Application No: FG/24/21/HH
Site Address: Pansas House Letchworth Close Ferring BN12 5RE
Description of works: Ground floor side extension, alterations to elevation, addition of a sun terrace, extension to existing garage, first floor front, side and rear extensions.

OWPC34626

Drawing Title: Proposed Loft Conversion and Extensions
Planning Permission

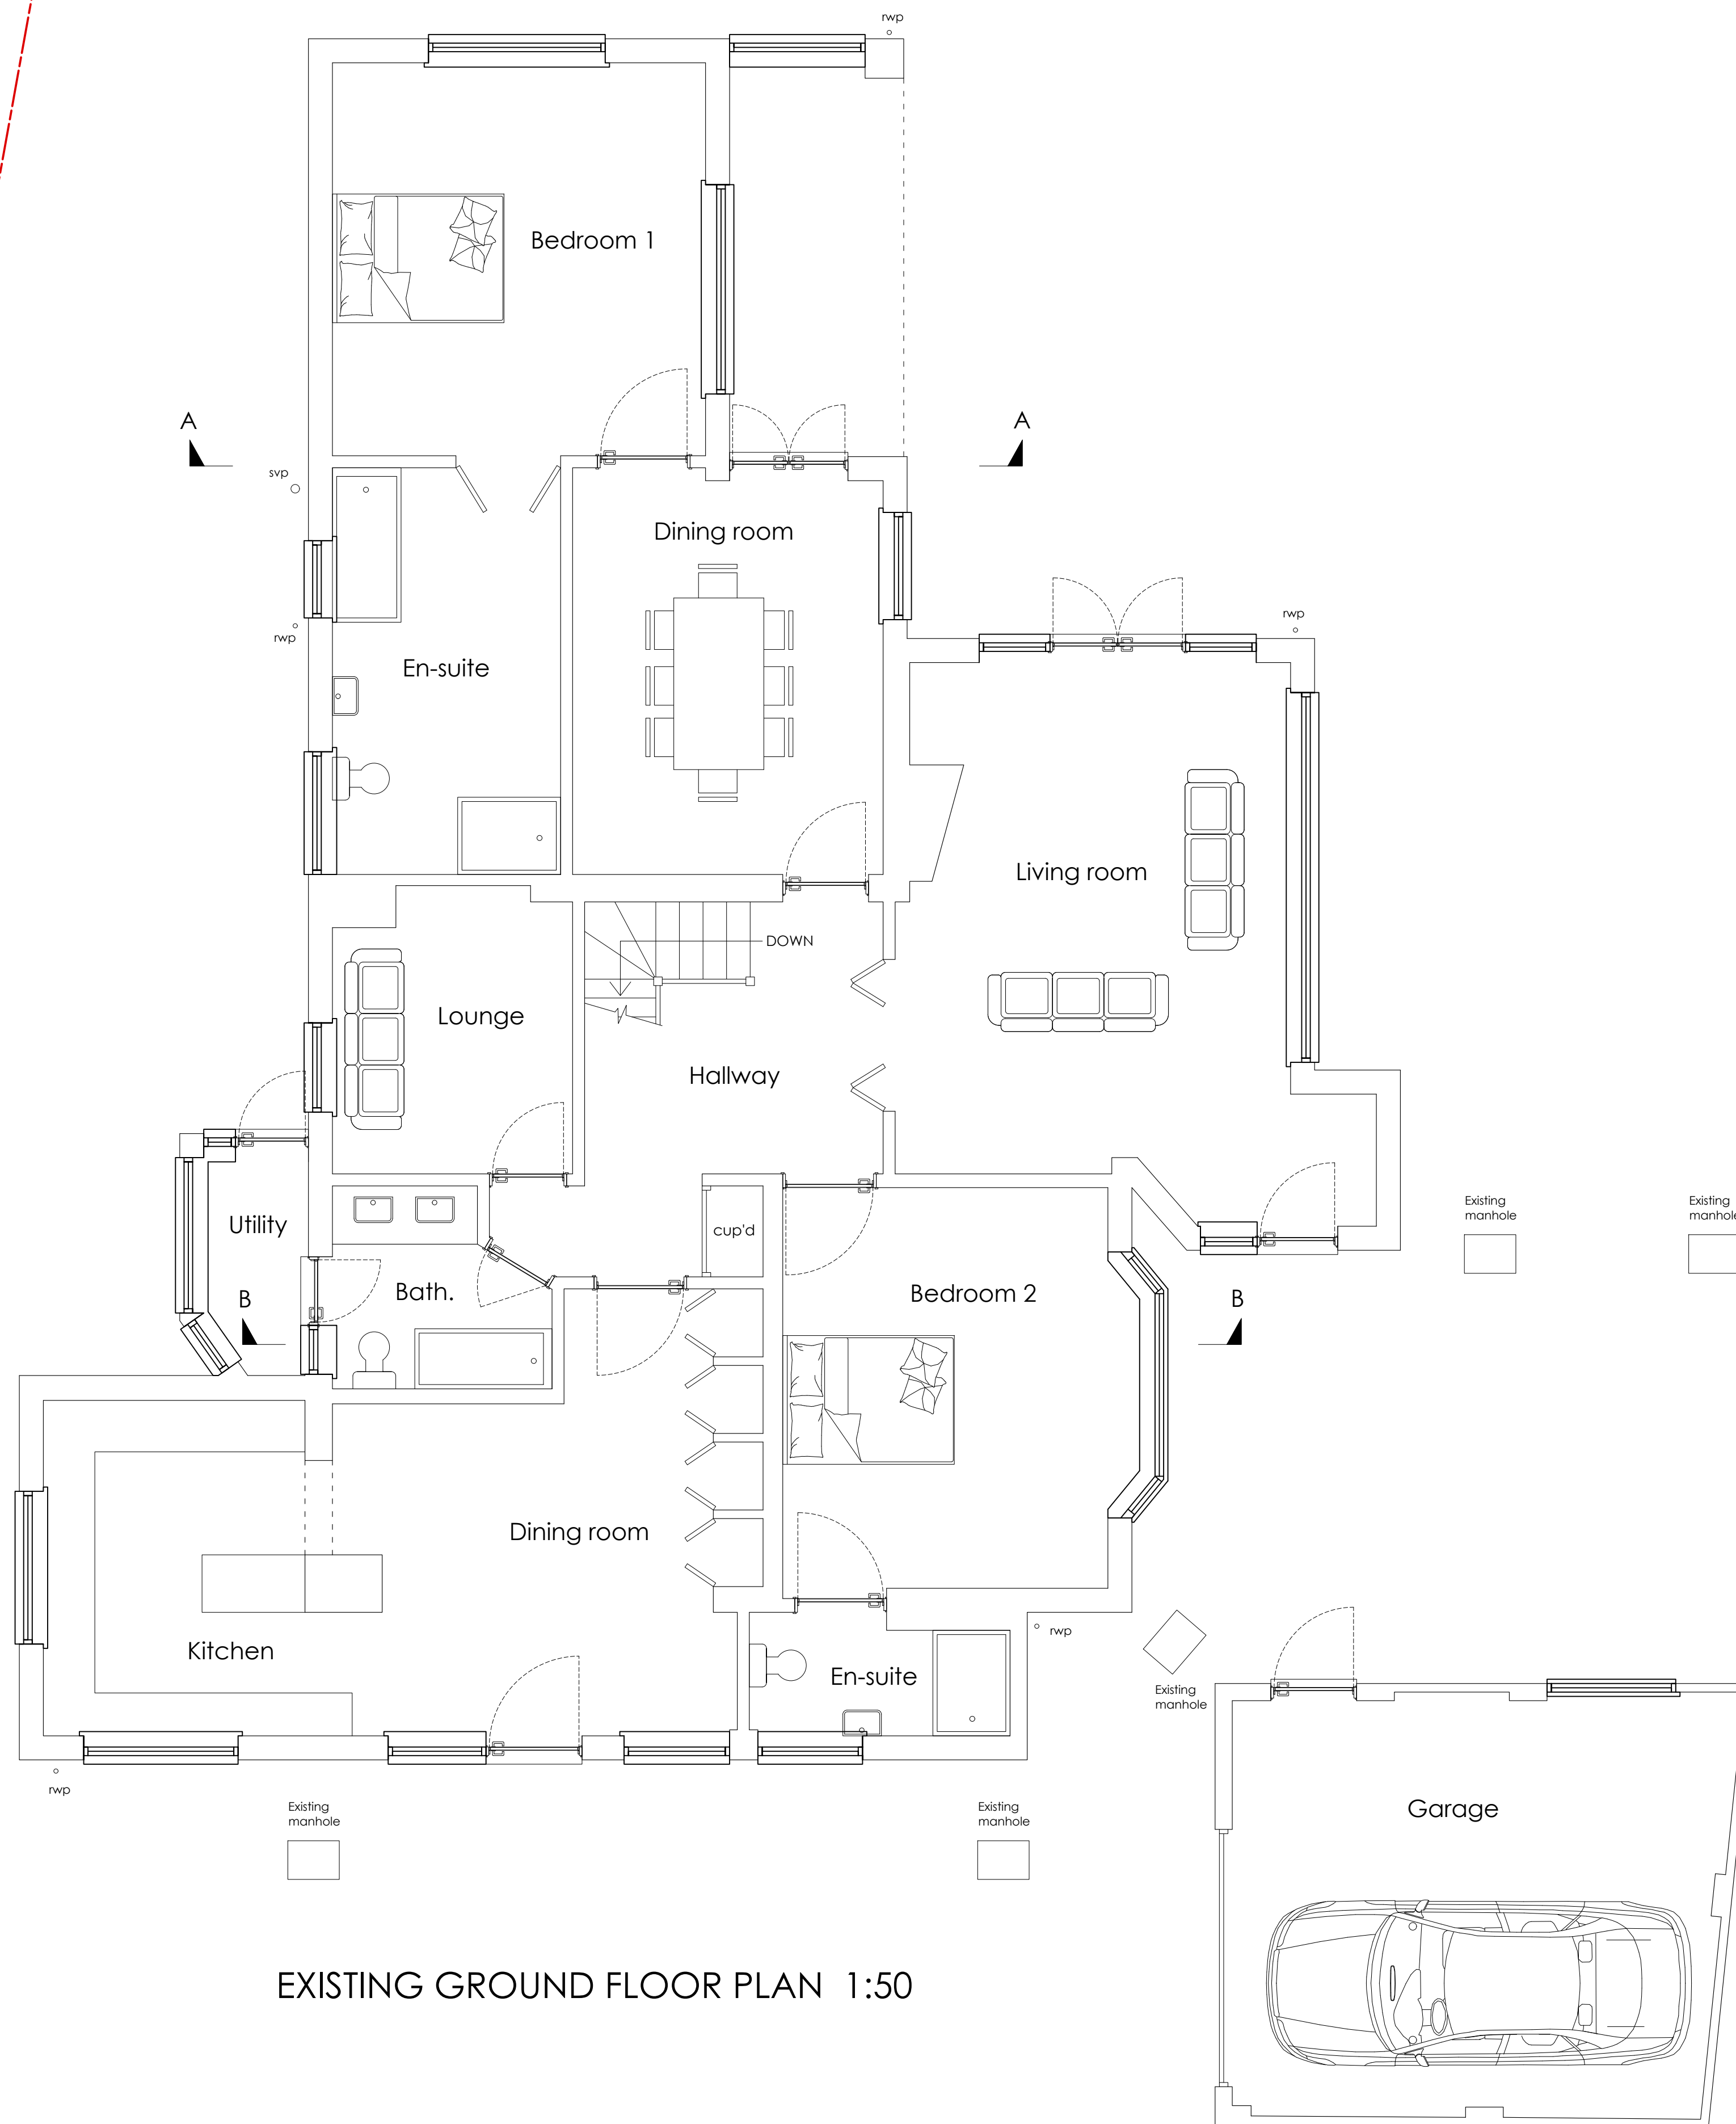
Ferring Parish Council objects to this proposal with particular concerns regarding the first floor balcony. The size and mass of the development is significant, creating an overbearing presence on its neighbours. The inclusion of a large first floor balcony which overlooks neighbouring back gardens will be imposing and depriving neighbouring residents of the privacy and level of seclusion they currently enjoy when utilising those outdoor spaces. The gardens are valuable features of the properties and overall setting which creates the distinctive village identity which is in contrast to the more intensively developed adjacent settlements.
